**Coastal Grove, 1 Survey Street Lennox Head (MP06_0002)
Response to Submissions**

I refer to your letter of 4 December 2006 regarding submissions to the public exhibition of the Environmental Assessment for the proposed residential subdivision and associated works at 1 Survey Street Lennox Head.

Revised Plans

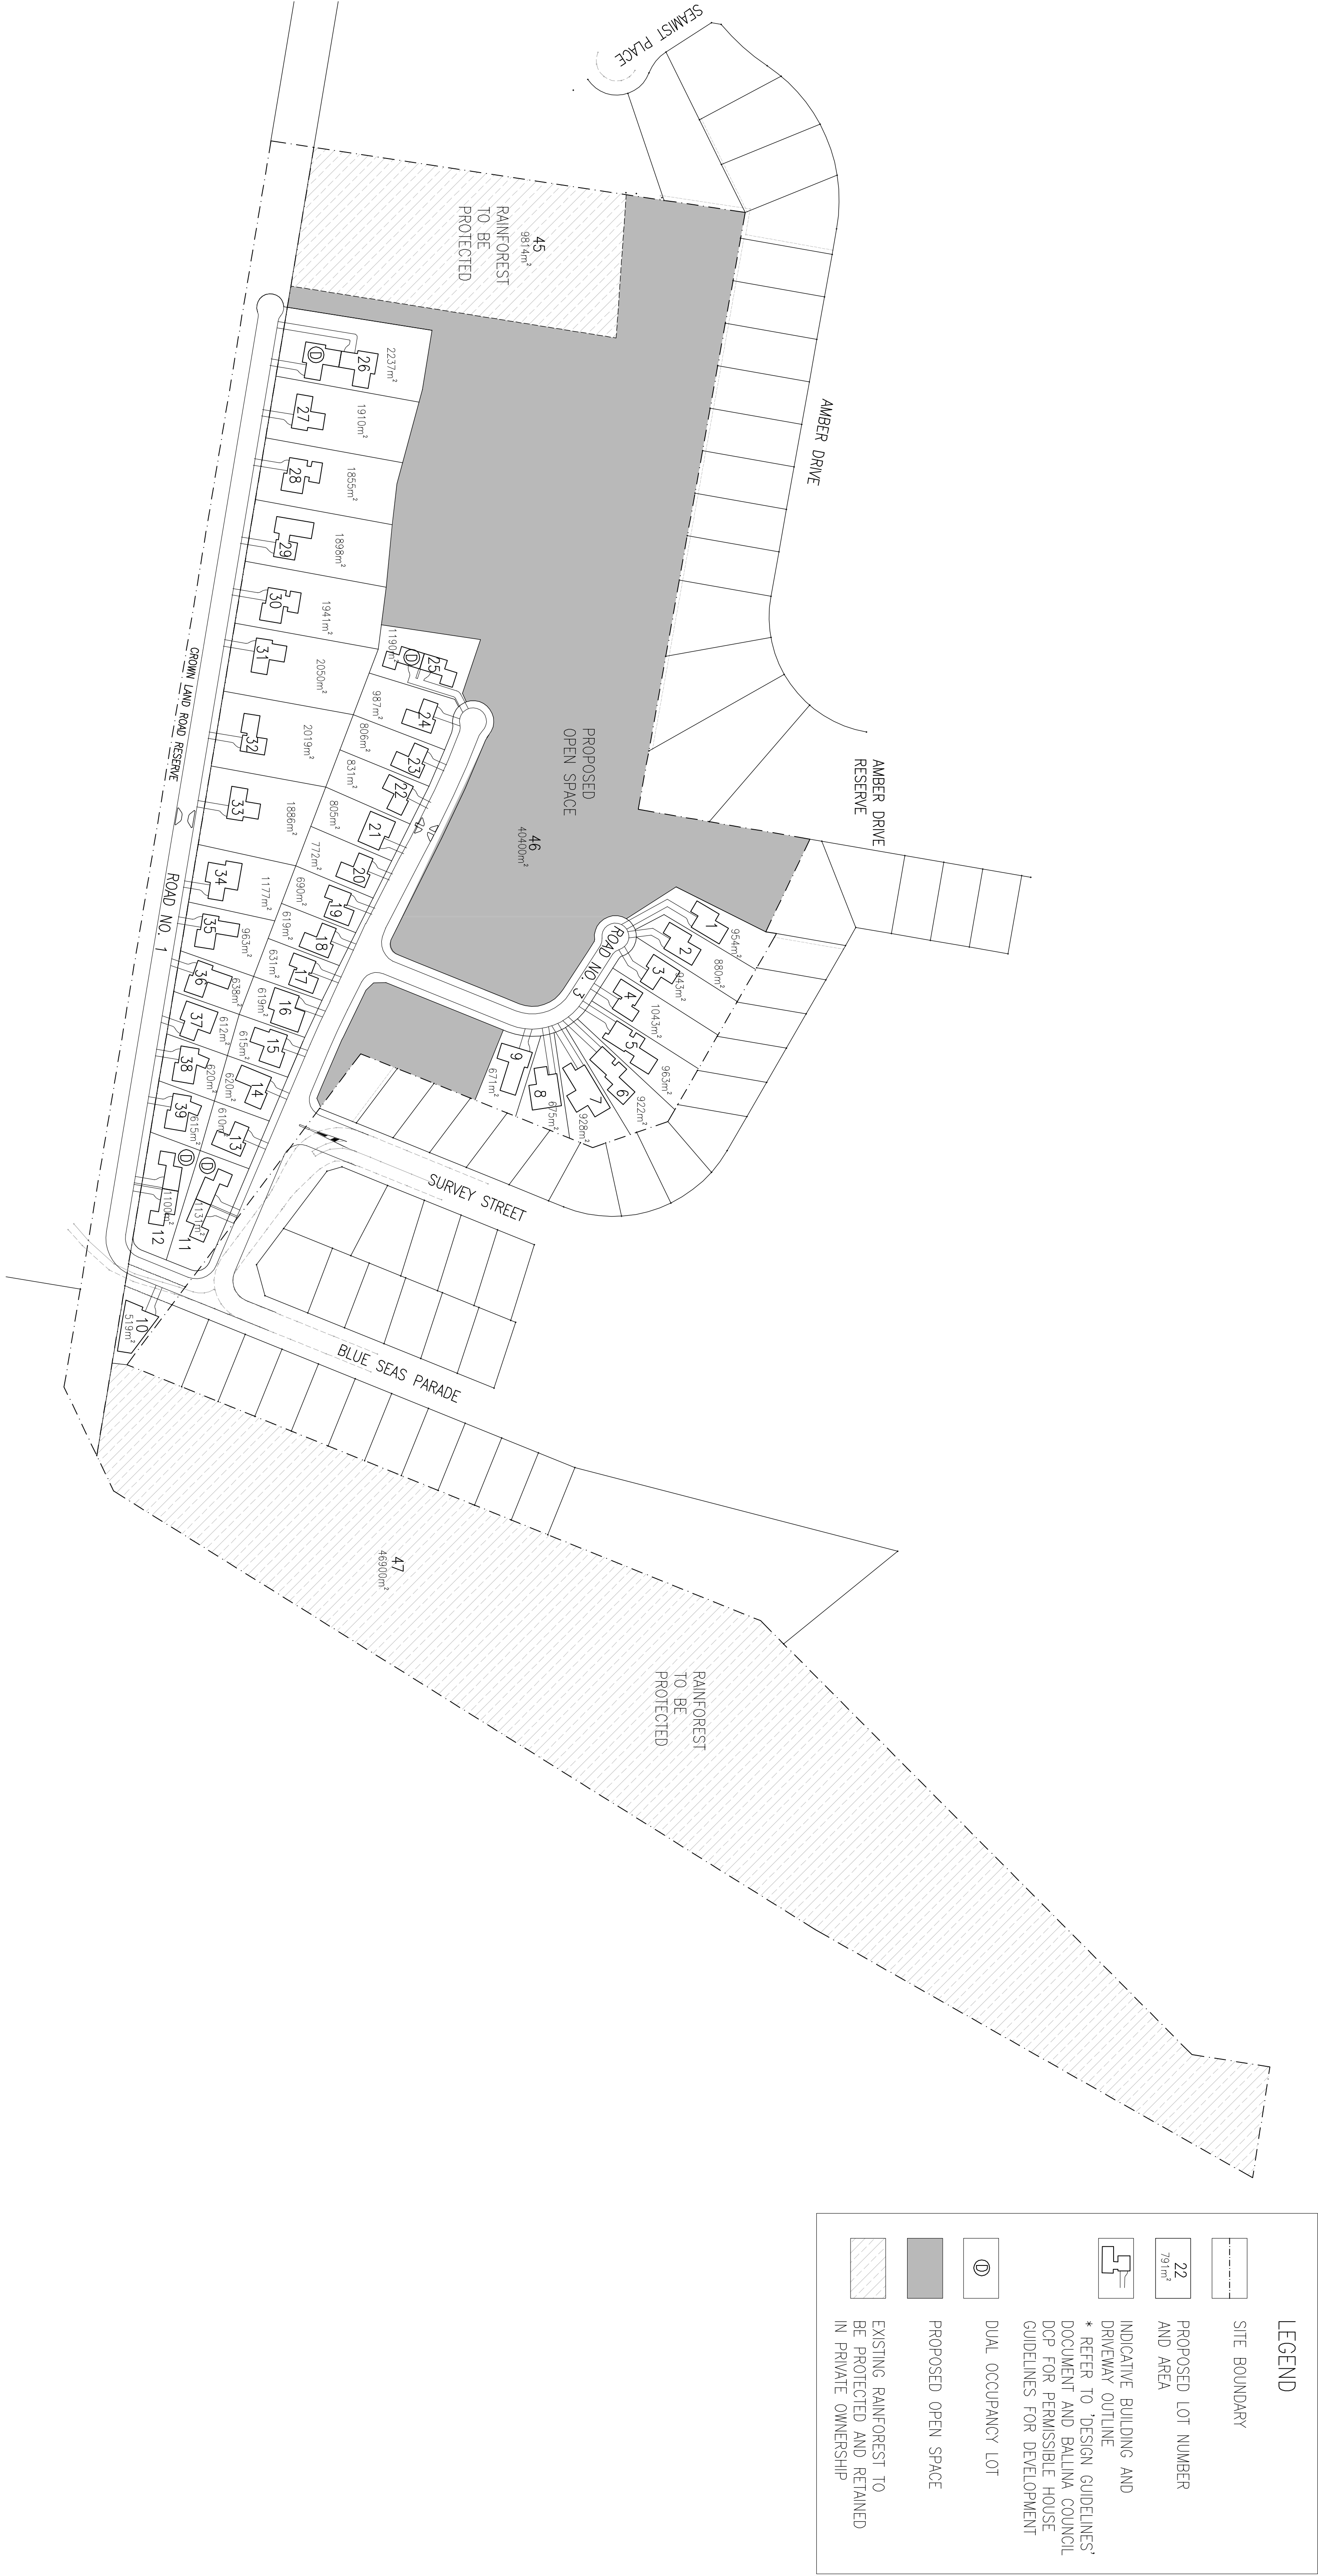
1. We have now deleted Lot 1 and illustrated an increased landscaped buffer to Amber Drive reserve. We have plotted the location of the Coastal Fontainea based on Council's survey position (see amended Landscape Plan dated 14 December 2006). We believe an adequate buffer is now provided which balances Council's request to limit the areas of additional open space and Council/DEC's request for additional buffer areas. Refer to further discussion under DEC.

5. An adequate riparian buffer has been provided. A distance of more than 50m is provided from the centerline of the creek to the nearest residential lots. The 20m offset from the drainage corridor is also illustrated on the landscape plan which is fully contained in the riparian / open space corridor. DNR, DPI and other agencies are satisfied with the riparian corridor.

FIGURE 1

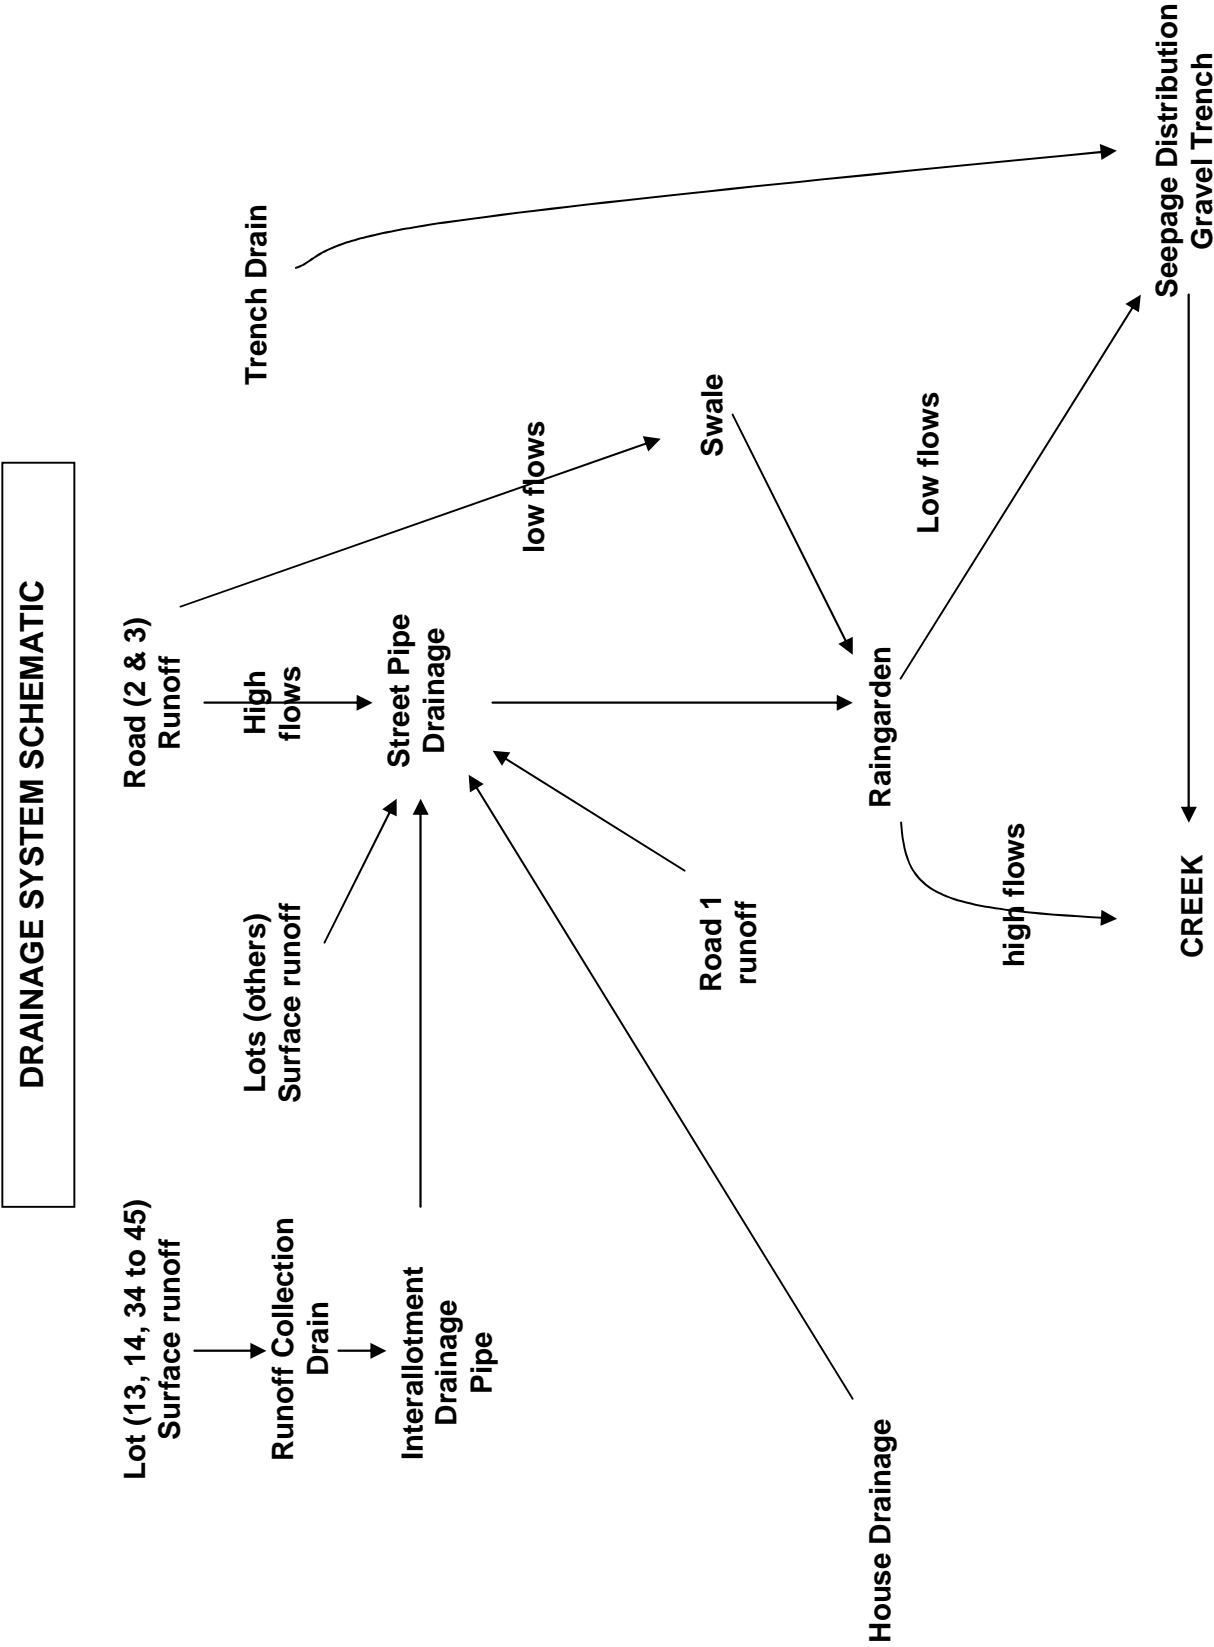
6. All drainage connections have been clarified in the attached Figures 1 to 3. The low flow from the raingardens would be discharged to the seepage distribution trench gravel drain. This would permit a slow and evenly distributed discharge to the creek which would not cause scour.

- the seepage will be collected in trench drains and will be separate and independent of the street drainage system. The drainage pipes from these trenches will direct seepage to the seepage distribution trench gravel drain (refer Figure 2). This trench will permit gradual and distributed seepage of this water along the creekline to replicate the boggy nature experienced in the existing conditions. In this way, the boggy nature of this area adjacent the creekline will be maintained. This is the dominate hydrological process affecting the Hairy Joint Grass and the hydrology experienced by the grass will not be changed;
